Oulton Parish Council

Oulton Parish Council's observation on Applicants response at deadline 8 re Noise Assessment for The Old Railway Gatehouse and OTMP (deadline 8) for Link 68

Figure 1 Location of Old Railway Gatehouse

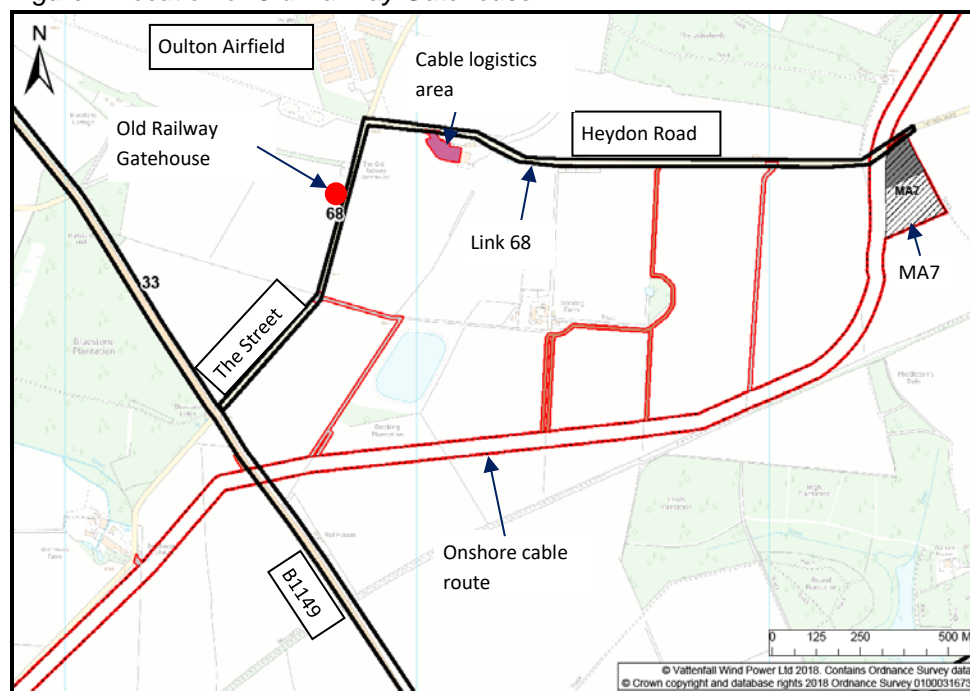
The Noise Assessment and the use of 18hrs as the methodology to produce the final results has assumed that the routes will be used in the same way as existing traffic, and that inputs to produce a noise model would be a generic mix of vehicles as currently exists, spread out over those 18hrs (day time). The model for NV/HOW3 is different as there are known numbers of vehicles, type and operating times.

The averaging of traffic noise over 18 hours gives the wrong outcome when the majority of the construction traffic will pass The Old Railway Gatehouse over a **12 hour** period and if Peak delivery time restrictions are imposed for HGV's on LINK 68 as well as other routes this will further impact by adding to the hourly rate of traffic movements over a reduced **10.5 hour** working day; the assumption is that the same number of vehicles will still have to run daily to meet the demands of the construction process or the construction process will need to be extended.

The outcome for traffic noise at any given point along a route is governed by the project working hours, imposed peak time delivery restrictions, the speed of traffic and a roads ability to function exactly as assessed; this is not what happens in reality. **The reality of Noise generated over a concentrated 12 hour day (or 10.5 hours if peak time delivery restriction is imposed) will be different from the 18 hrs as in the Noise Assessment and will be noticeable.**

The measured speed by HOW3 of 69kh (42mph) and 96.6kh (60mph) as used by Vattenfall to form the Noise Assessment is flawed as the whole of 'The Street' will be subject to a speed restriction of 30mph. This means the data input into the noise assessment is not correct for the projects lifetime.
